CITY OF PORTLAND
STOP WORK NOTICE

July 11, 2000

RE: Lot # 168 Milton St.
CBL: 333-E-033

PLOT PLAN

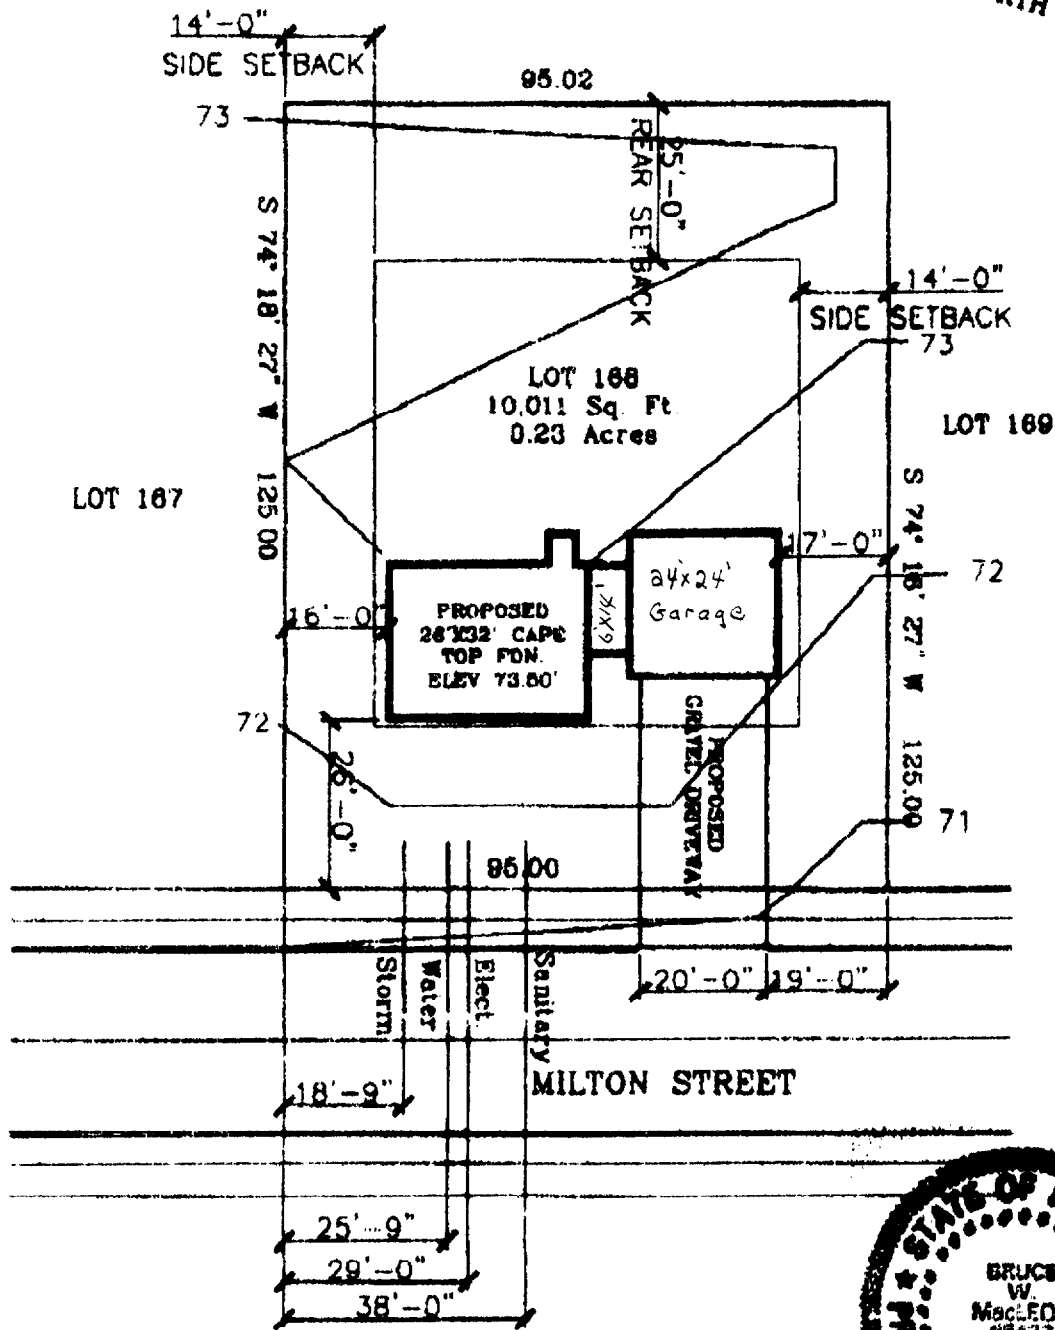
A site evaluation must occur to determine appropriate elevations and drainage.

FOUNDATION PLAN

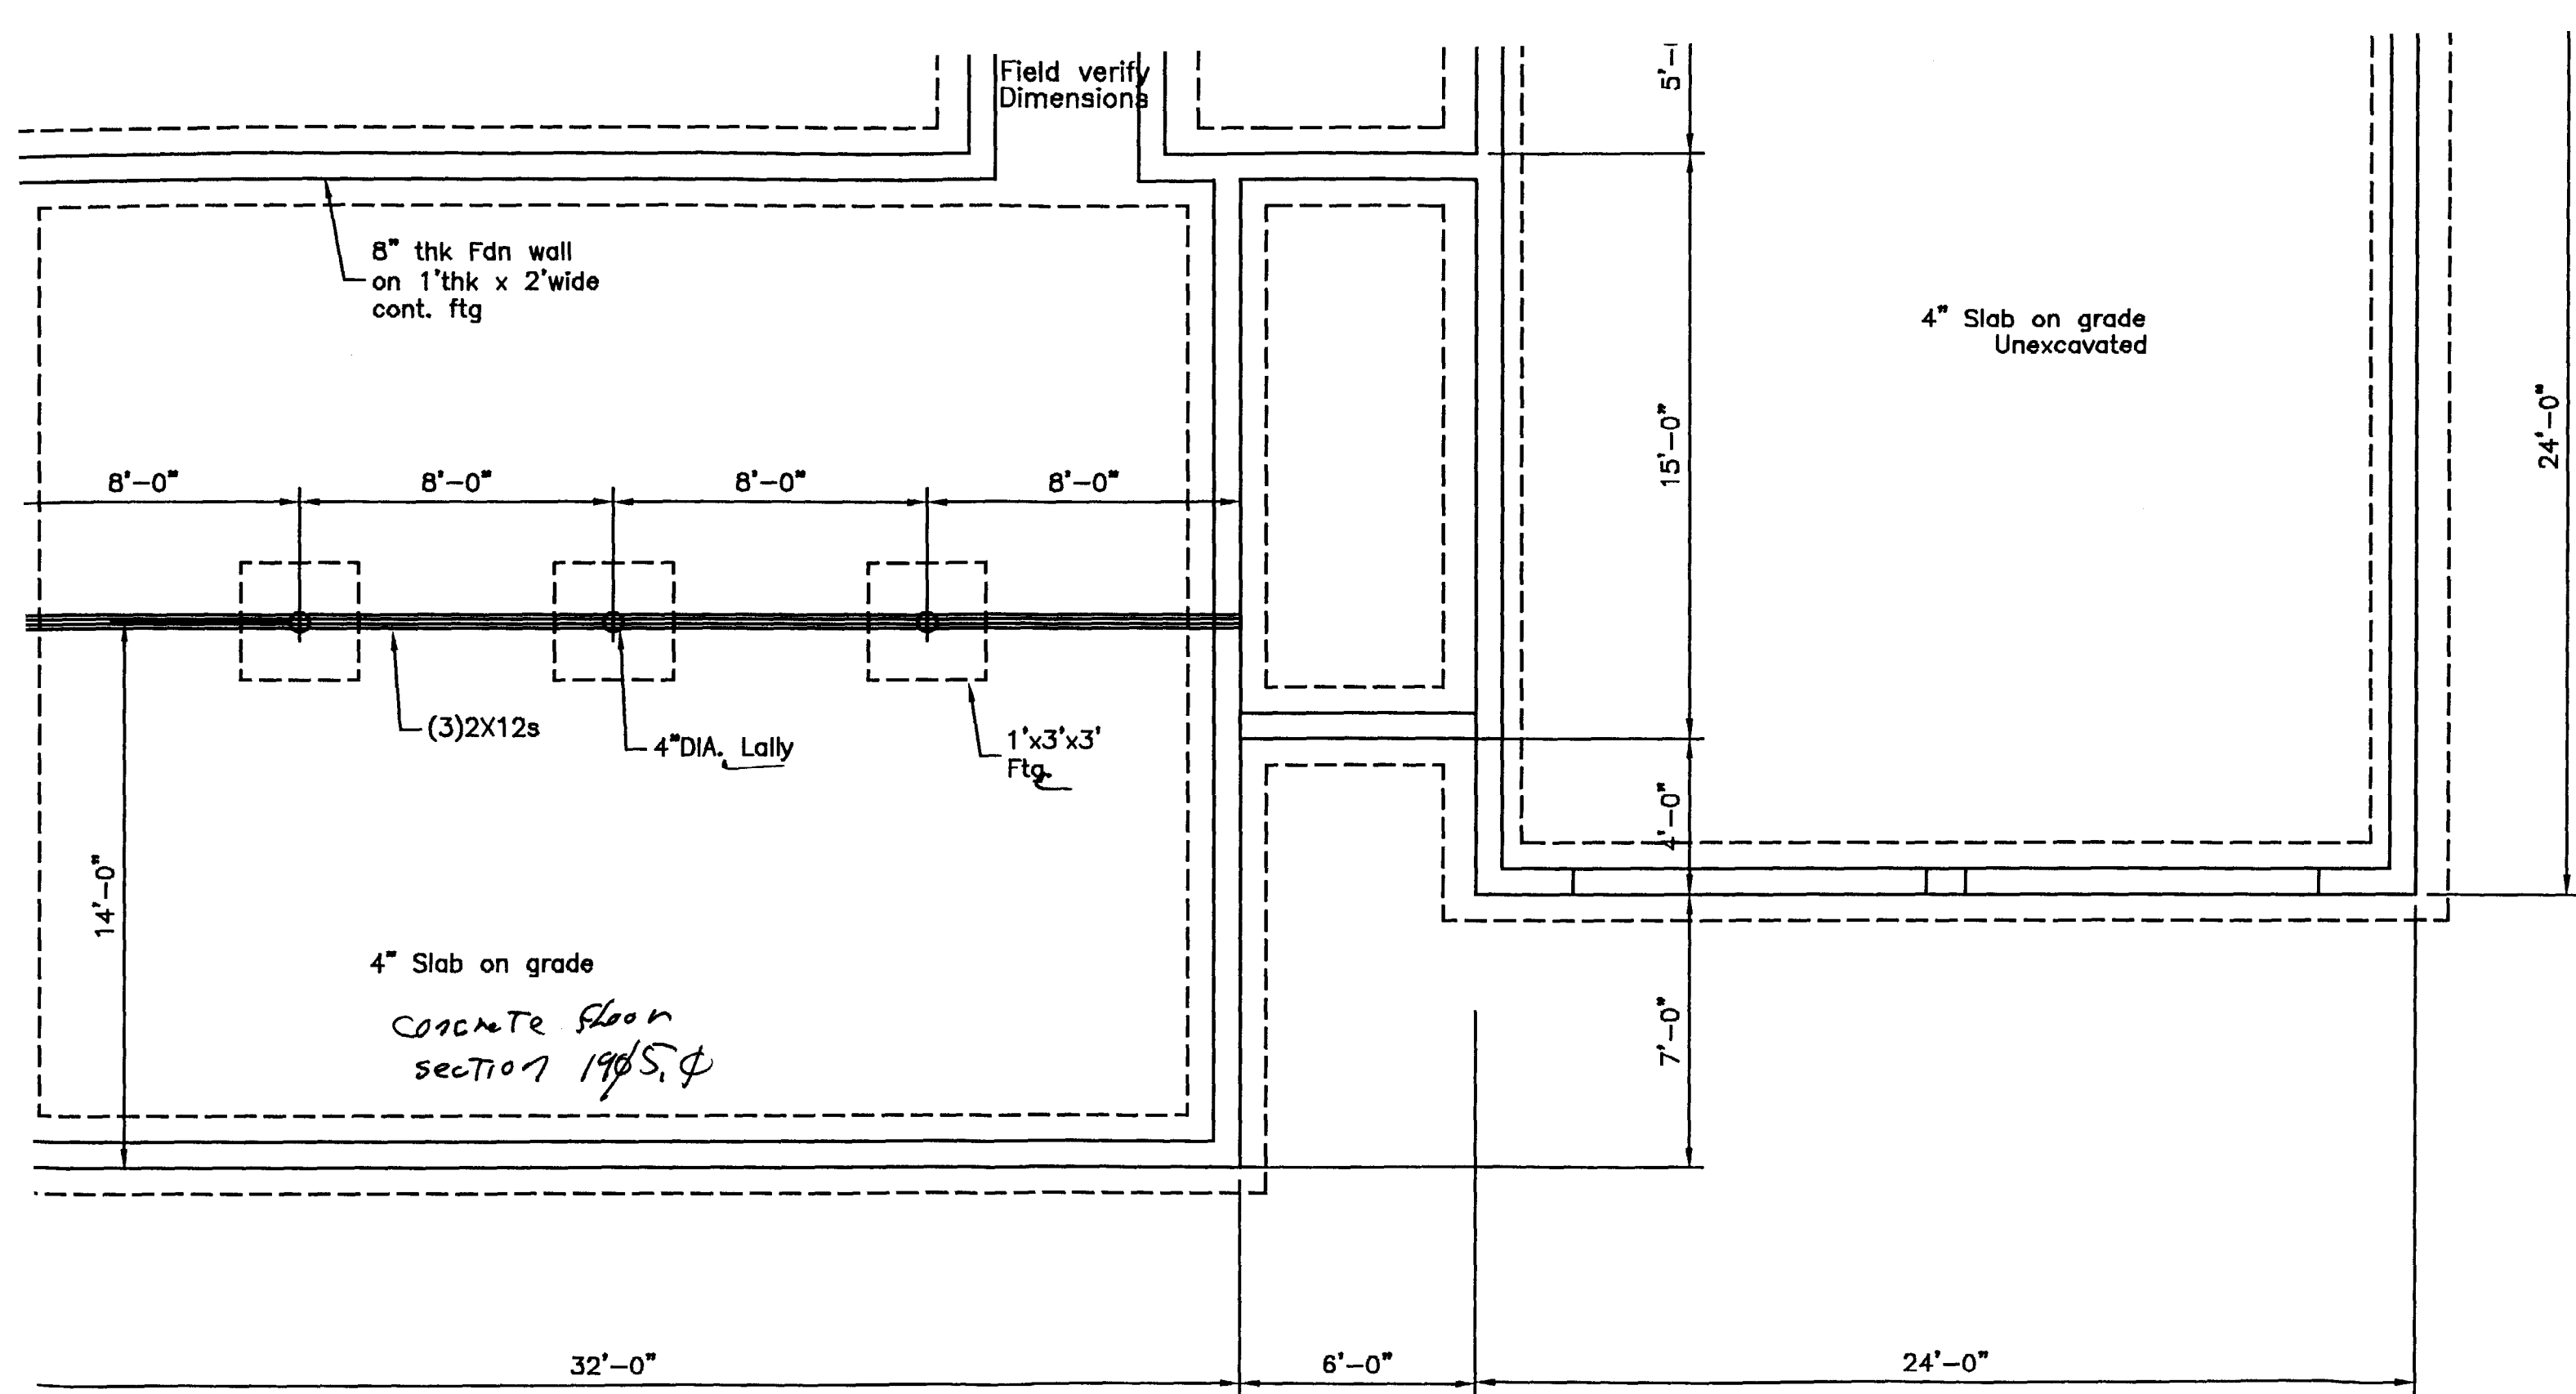
An Ammendment must be submitted with new as-built plans specifically showing the daylight basement plan and elevation plan.
